Tallawong Station Precinct South (SSD 9063) – (formerly known as Cudgegong Road Station South) – Notice of Exhibition

I am writing in reply to your request for comments from the Environment Protection Authority (EPA) on the above SSD concept for a SSD Application.

PETER BLOEM
Manager Regional Operations Illawarra
Environment Protection Authority

**Figure 6: Traffic Facade Noise Map  $L_{eq}$  15 hr – Southeast View**

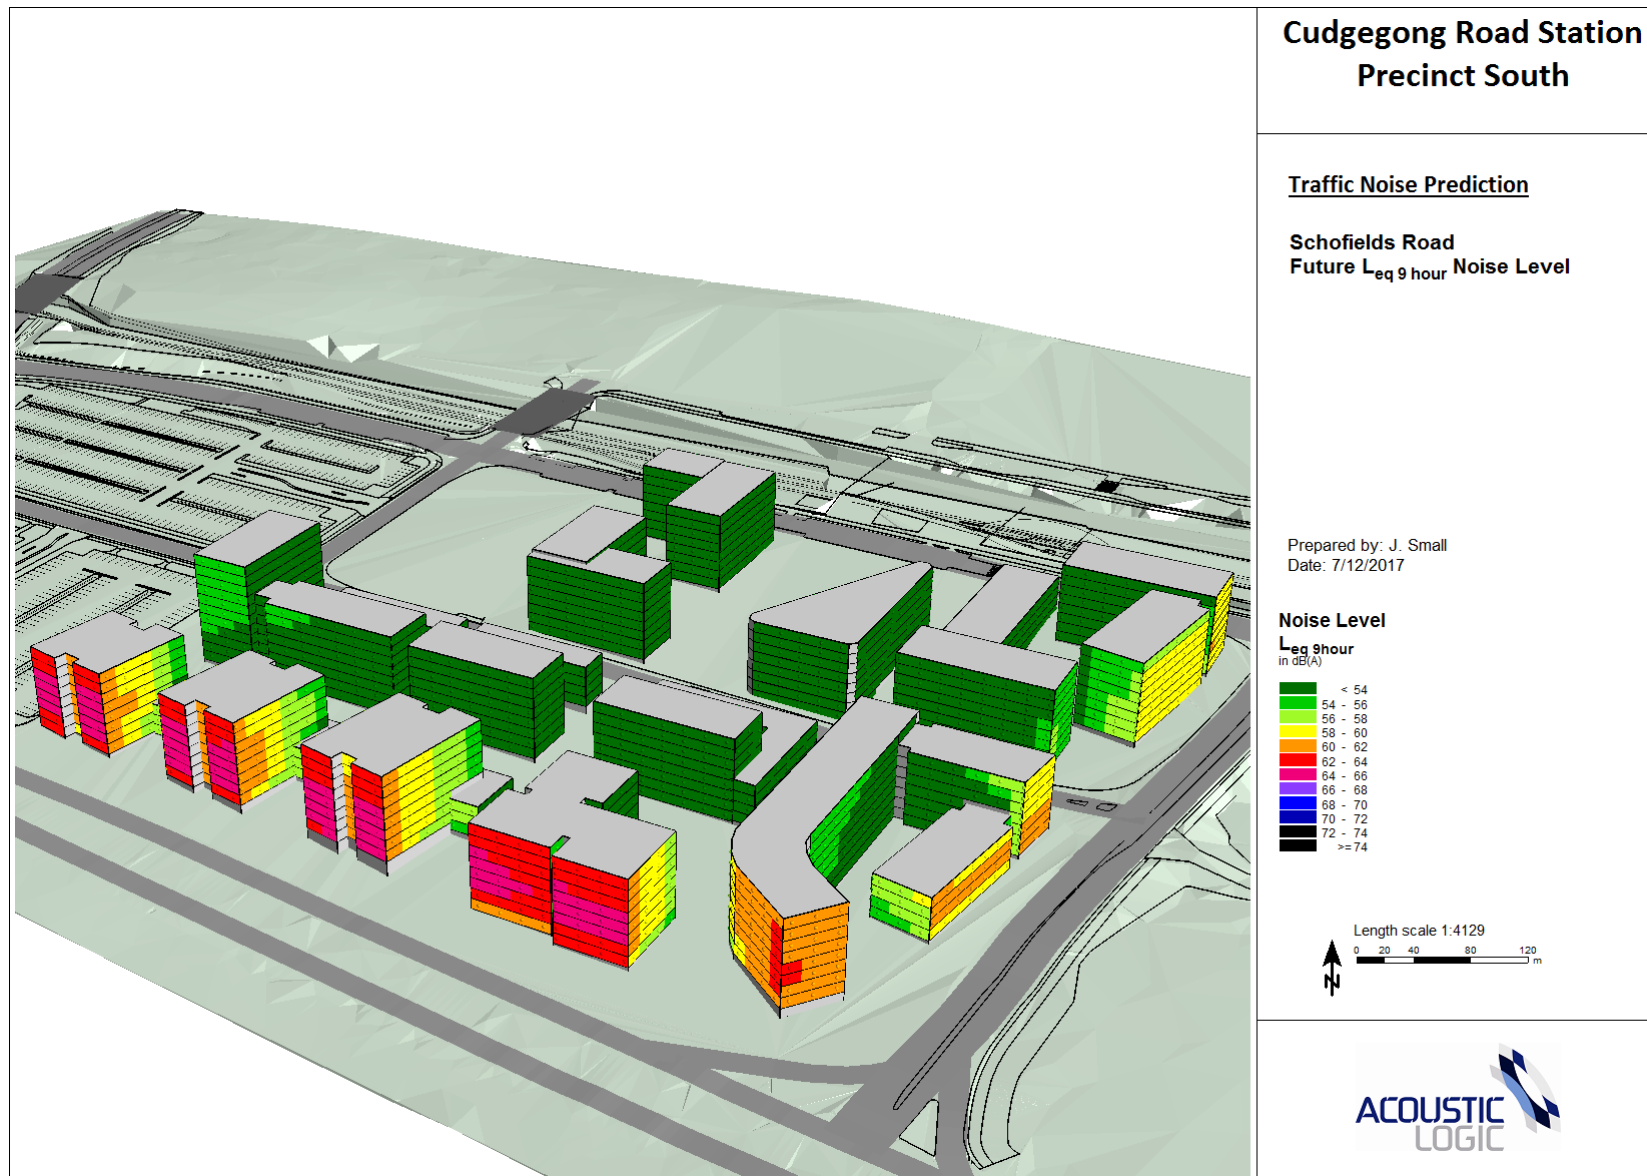
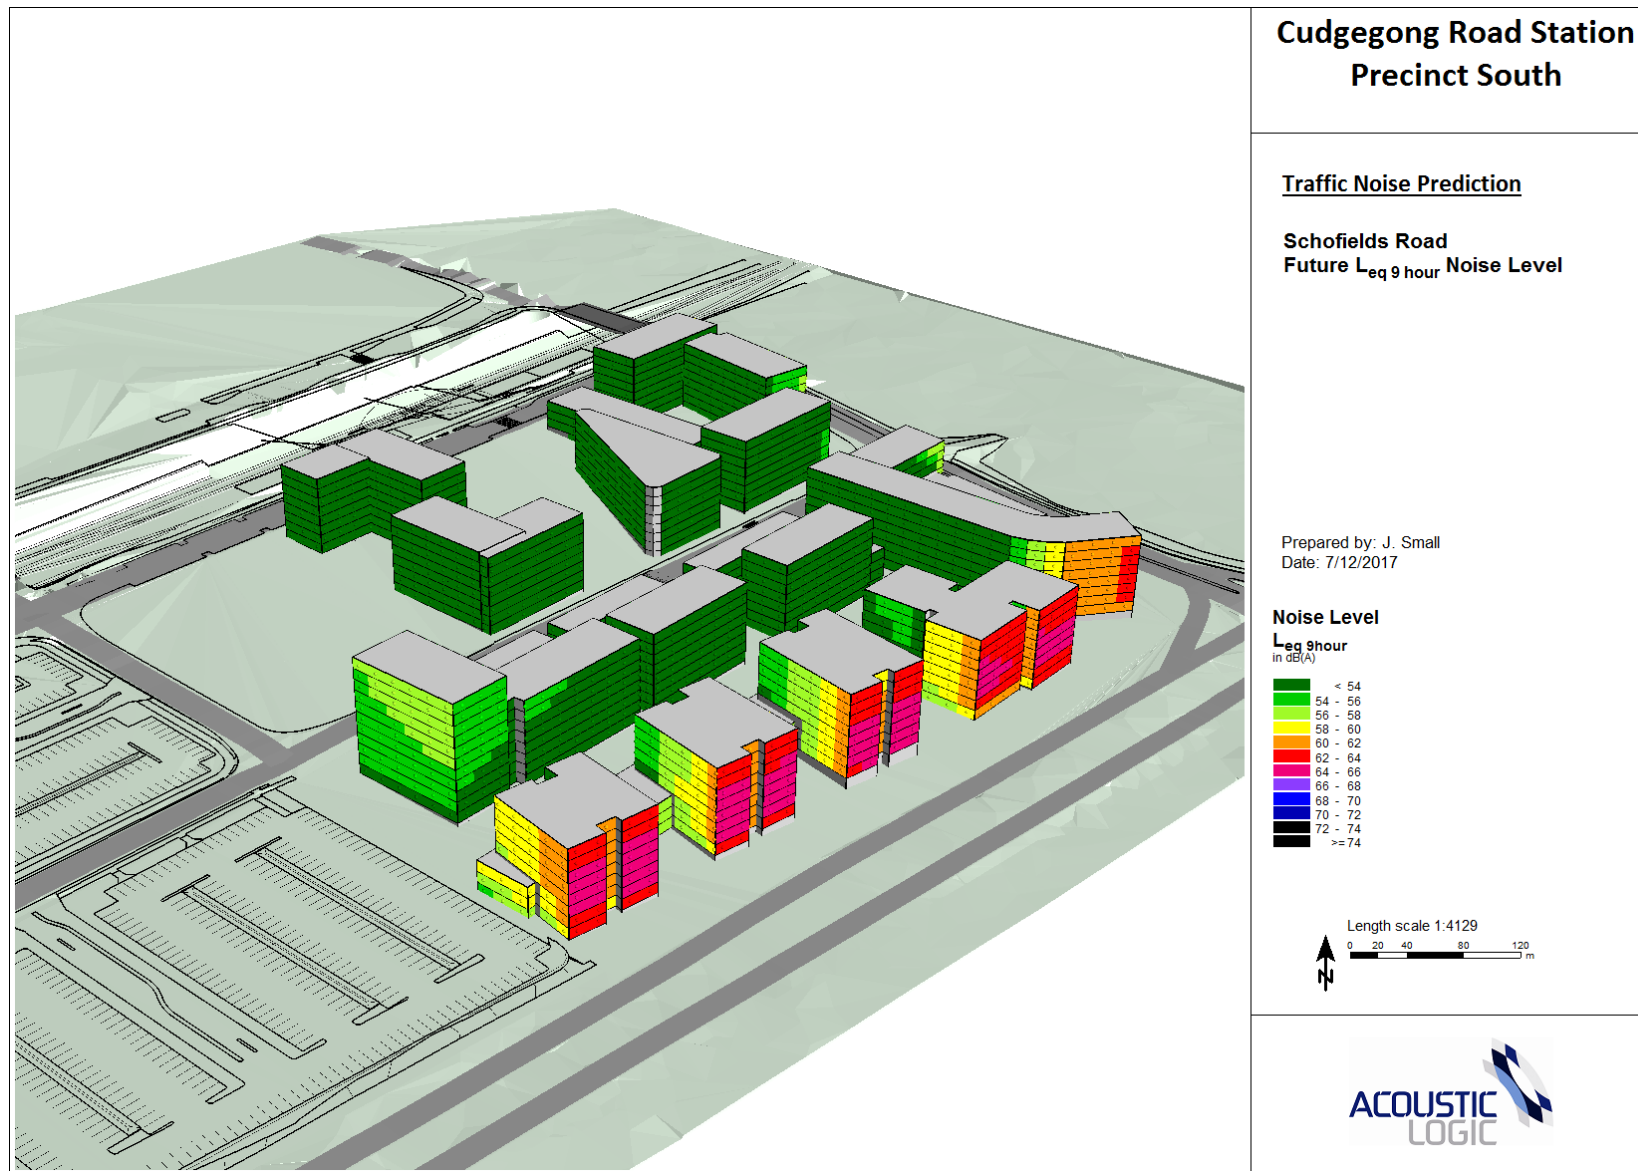
The SEARs require consideration of the *Development Near Rail Corridors and Busy Roads interim guideline (DoP 2008)*. The supporting Air Quality Assessment outlines the air provisions of the guideline, however, its only comment on applying the guideline is that the development location is such that there will be no emission impacts from Windsor Road.

The EIS traffic study indicates Schofields Road will carry traffic flows of over 2,300 vehicles per hour in 2035, approaching the guideline threshold of 2,500 vehicles per hour for which residential building setbacks of at least 20 metres are recommended. While the traffic flows are only predictions, it would be reasonable to consider potential impacts from Schofields Road, which is directly adjacent to development site.

For example, the supporting design quality guidelines consider and address a range of environmental considerations but do not explicitly consider air emissions exposure from Schofields Road. While some of the design proposals may reduce exposure incidentally (for example, varied building textures, space between buildings), it is proposed there will be under 15 metres separation between Schofields Road and residential buildings, with living areas proposed to front the road. Design approaches for housing next to busy roads from the Parramatta Road Corridor Urban Transformation Strategy should be considered. These include:

- Using architectural and design approaches that provide separation from major roads and ensuring habitable rooms of future developments are oriented away from busy roads.
- Where development includes mechanical ventilation (such as air conditioning), ensuring that the air intakes for the ventilation are situated away from pollution sources.
